EMBREY BUILDERS, LLC.

RFI

RFI #: 115
Date: 5/14/2012
Job: EB-02 Keller Springs Lofts
Phone: 877-777-5115

Subject: HVAC Supply Duct and Return Air Duct Locations

SHEET NUMBER
M-2.1
E1 &
A1 UNIT
MECHANICAL

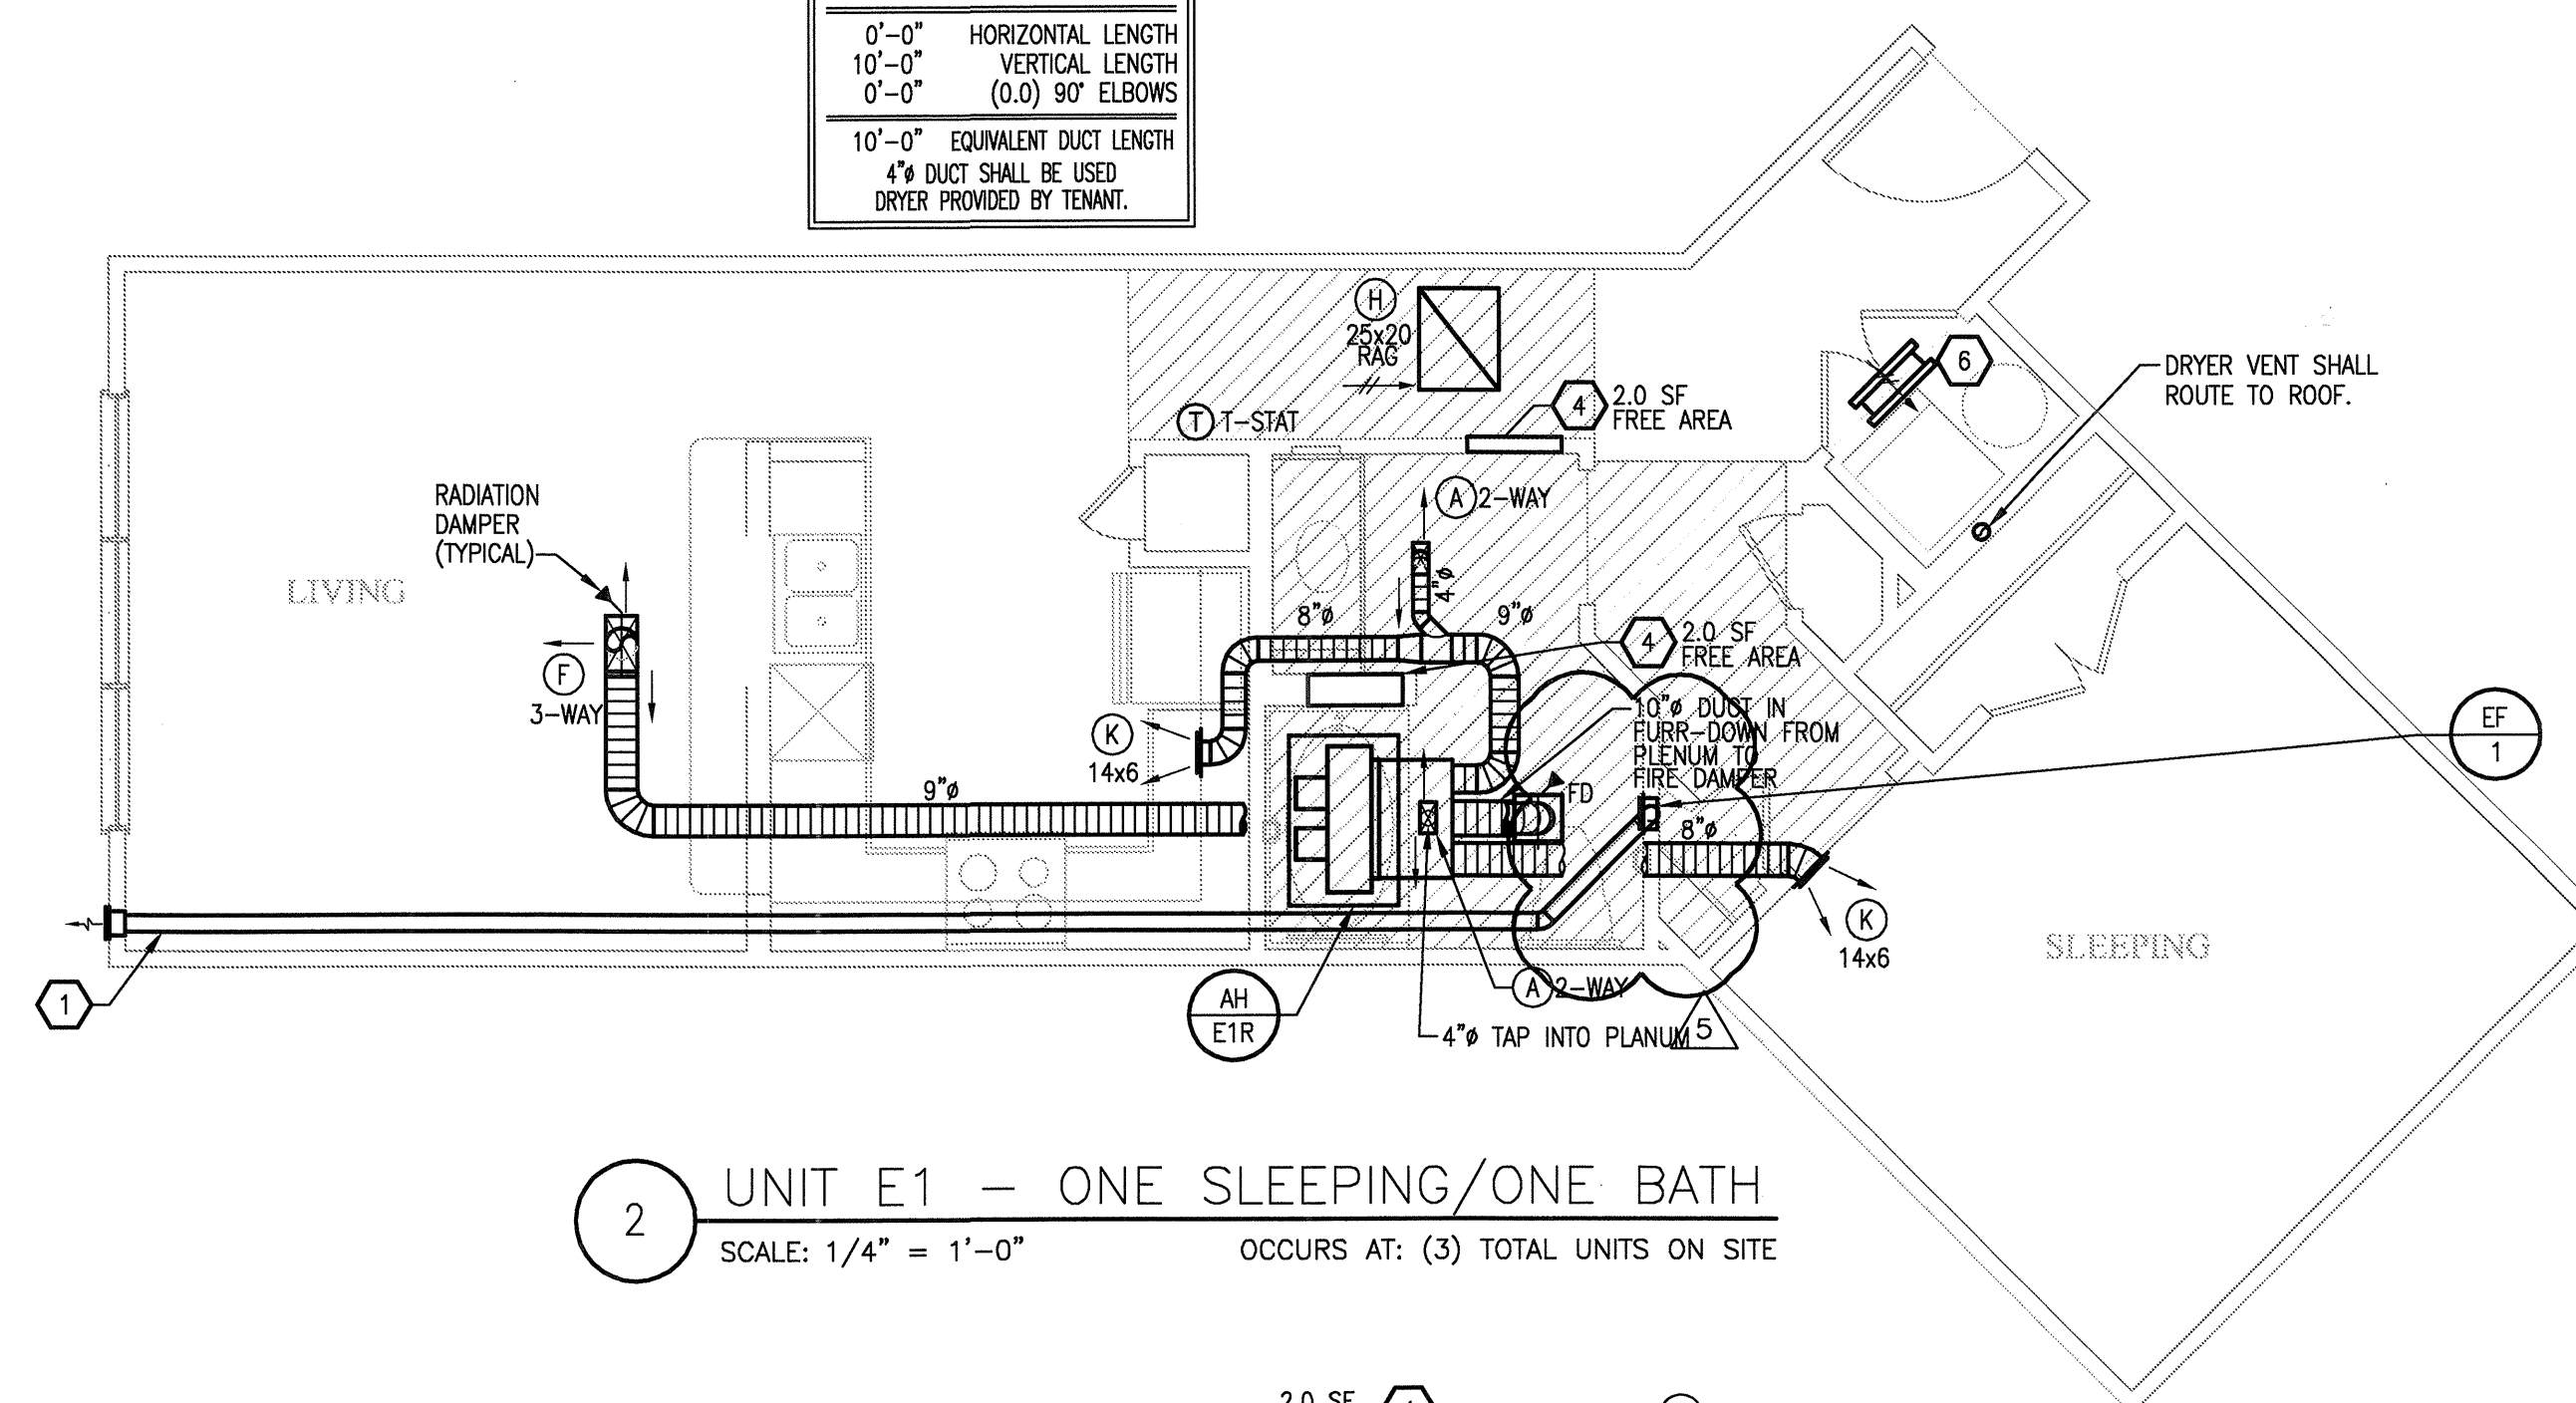
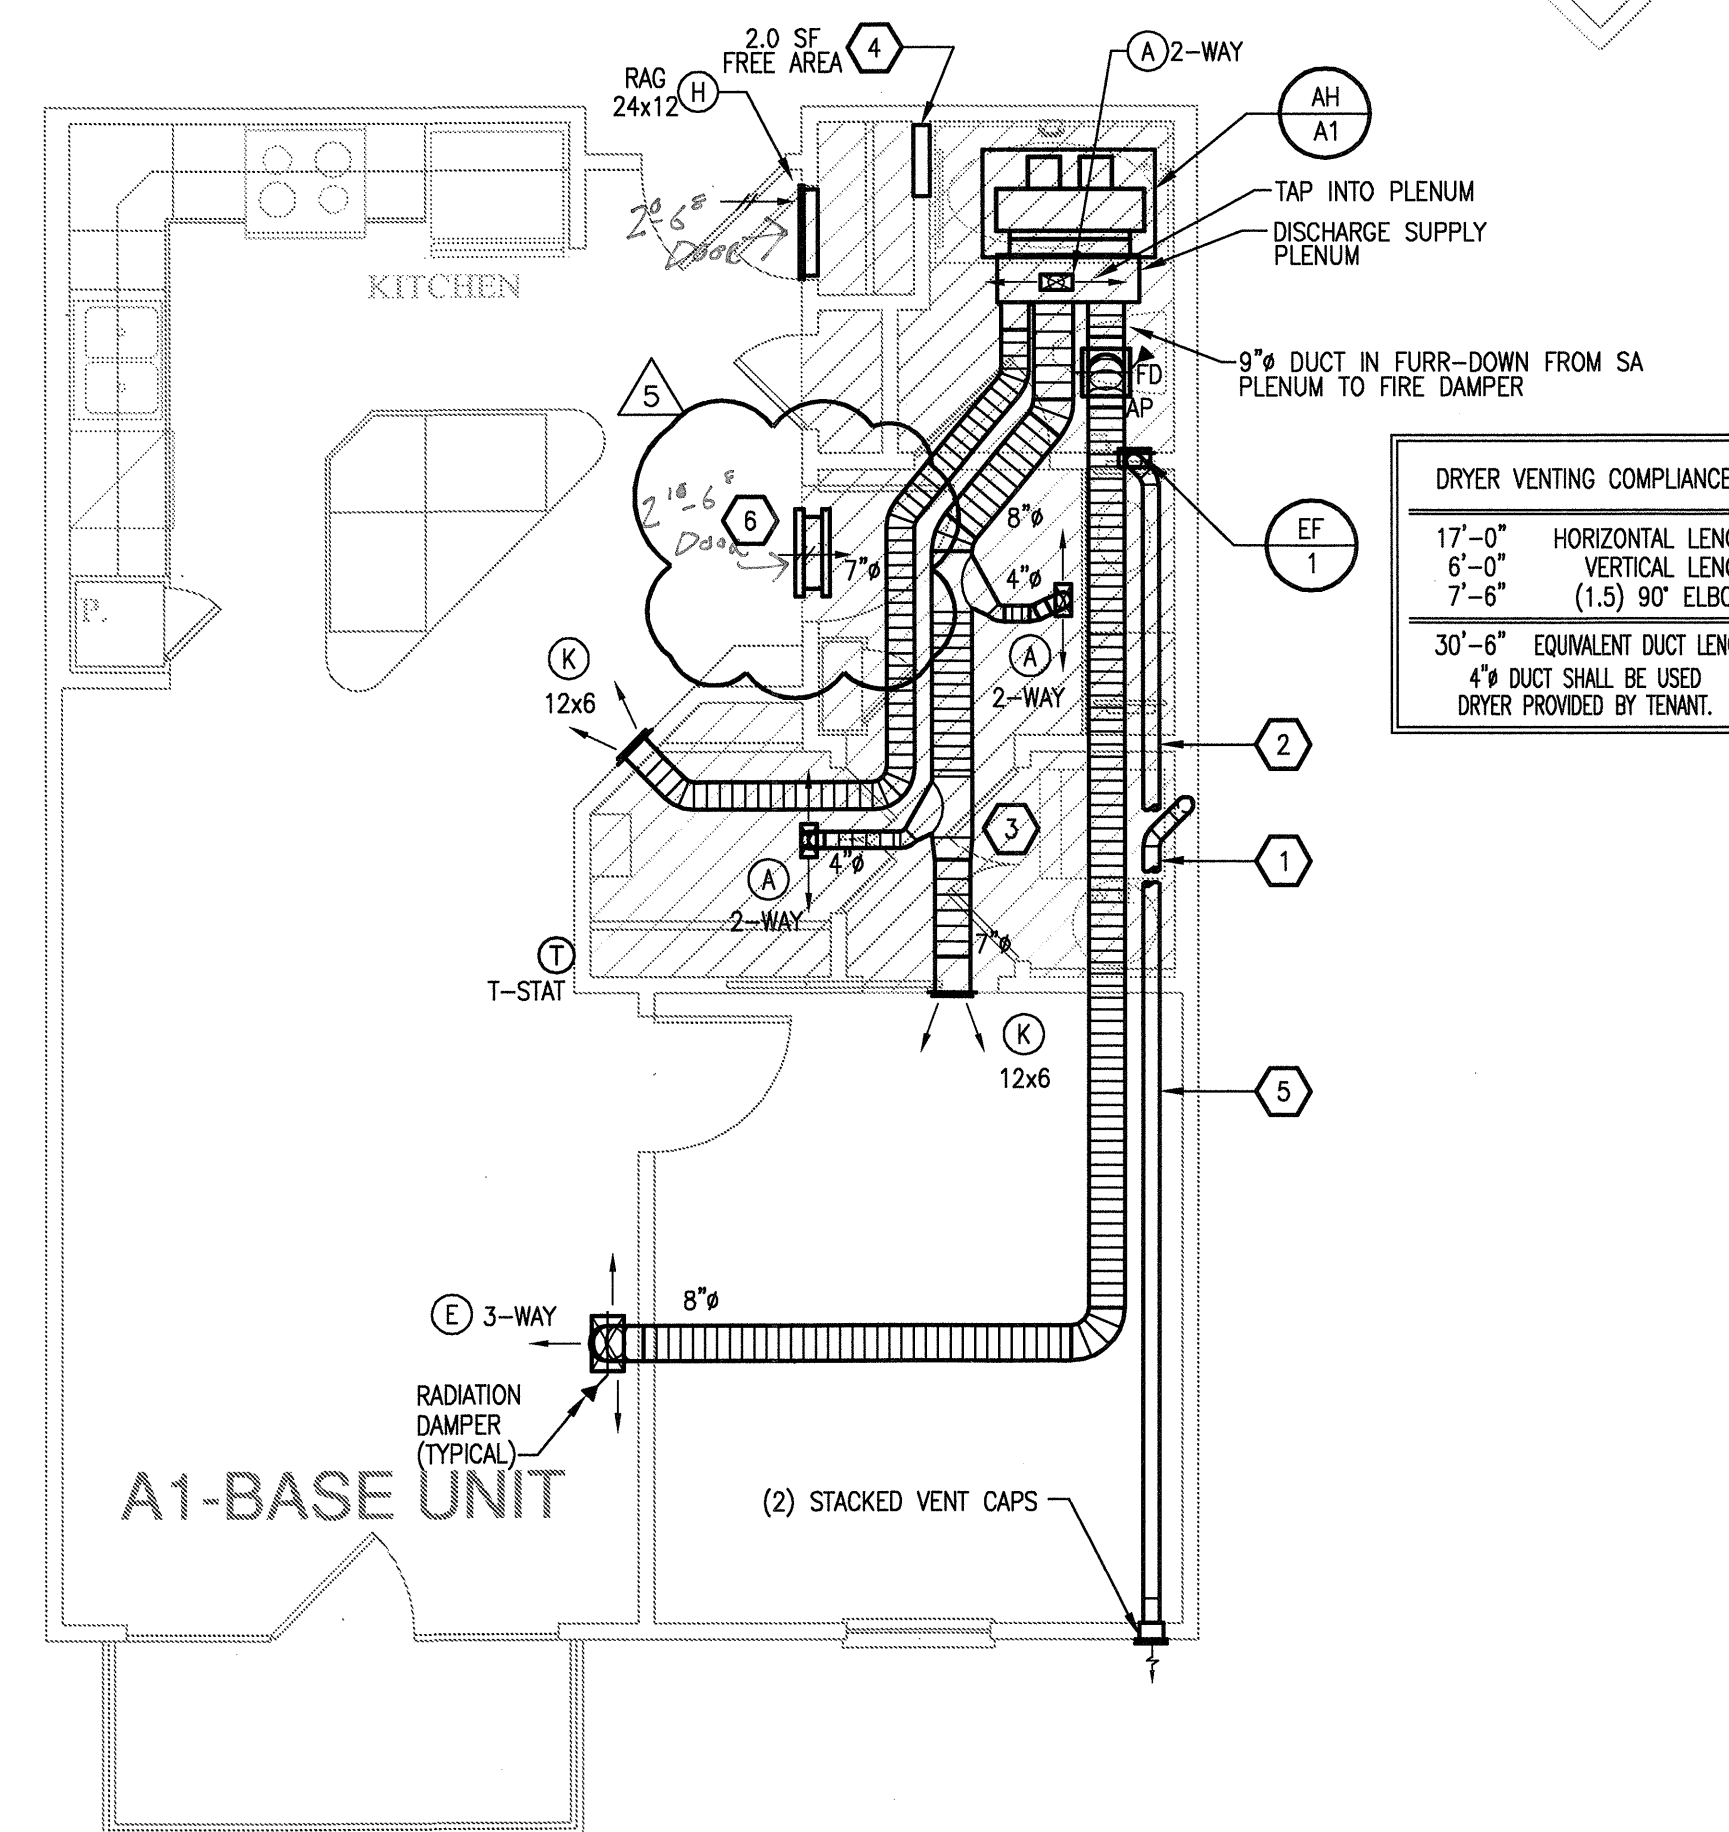
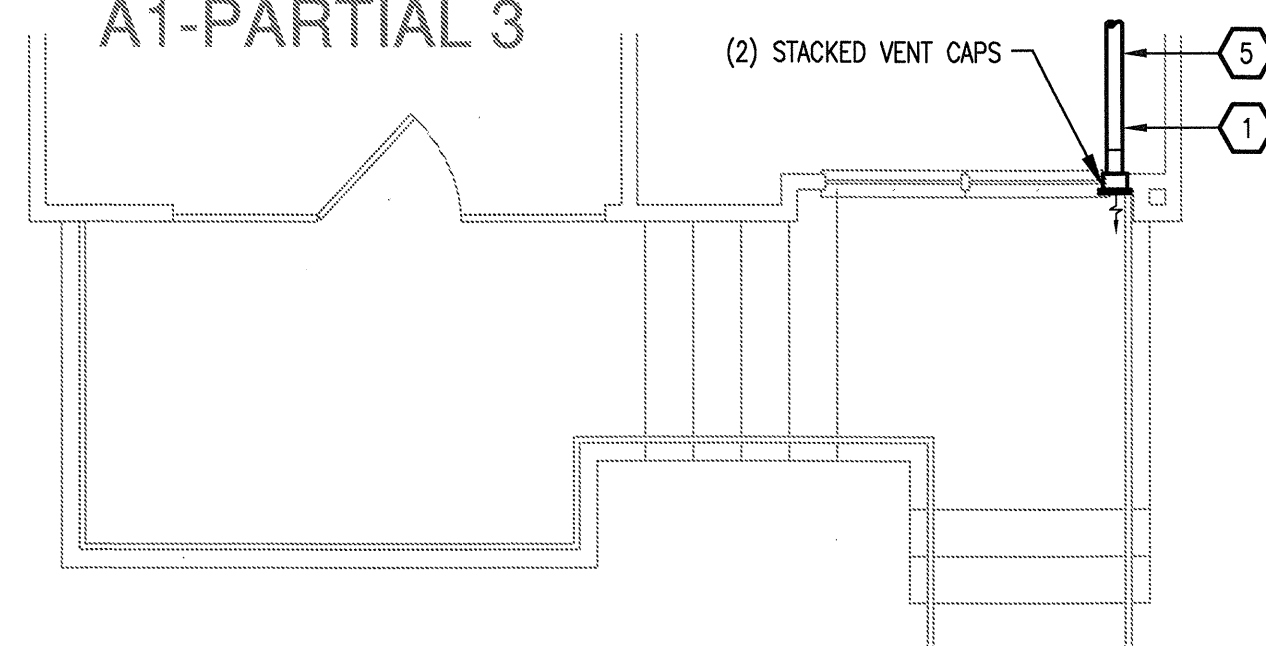
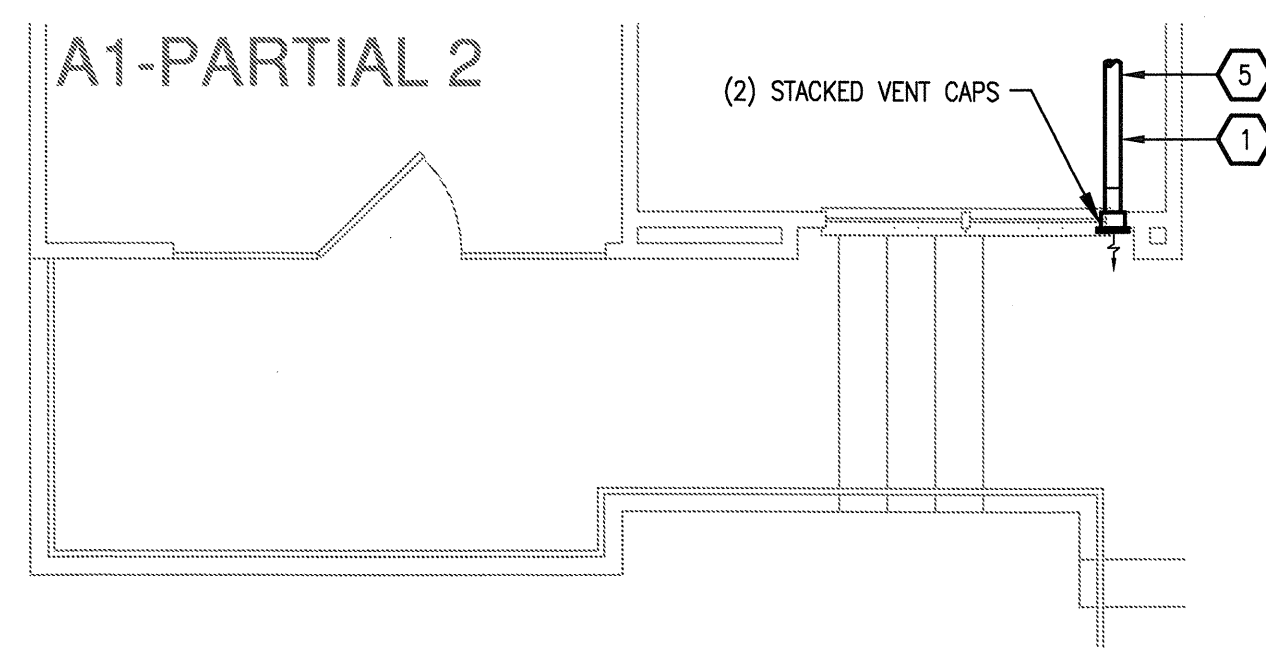
Request: **Date Required:** 5/22/2012
In the A1, A2, A4 and B2 unit types, there are either supply ducts or return air ducts terminating in a load bearing wall. Please provide a way to get around this issue.

Provide a type A header where duct penetration will not fit between the stud wall framing.
